**WEST SUSSEX COUNTY COUNCIL
INFRASTRUCTURE CONSULTATION**

SUBJECT: WA/56/09

9 Hunters Mews, Fontwell, Arundel

Repositioning of garden wall towards highway

Scale 1:500

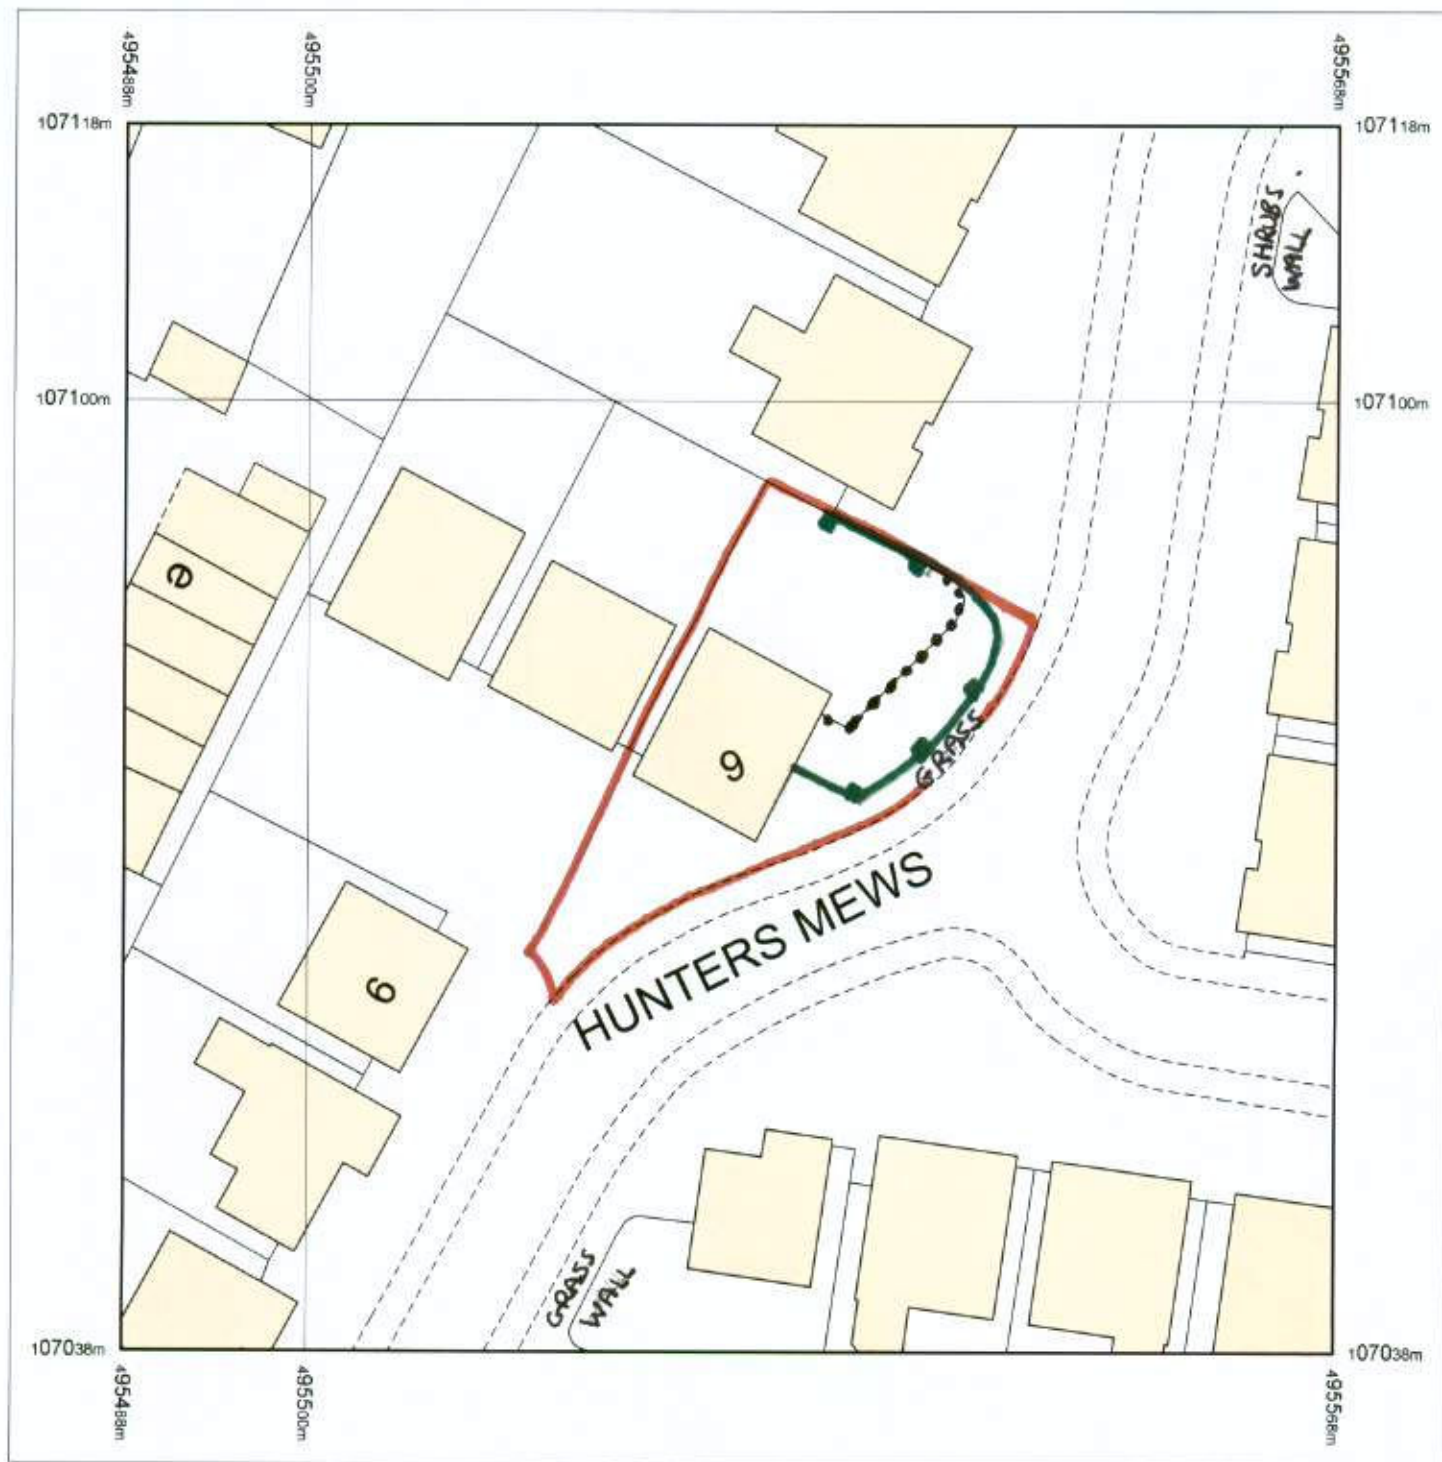
Furthermore, the new position of the wall would restrict forward visibility on the road, and prevent road users from seeing around the bend for oncoming vehicles. The wall would also obstruct visibility from the access of Number 10, which would not be acceptable to this authority.

WSCC would therefore be minded to raise an **objection** to this proposal in the interests of road safety. The proposal to reposition the wall closer to the highway of Hunters Mead will result in the new wall obstructing forward visibility for highway users as they approach the bend in the road outside No.9. In addition, it will obstruct visibility from the access serving No 10 Hunters Mead. All to the detriment of highway safety.
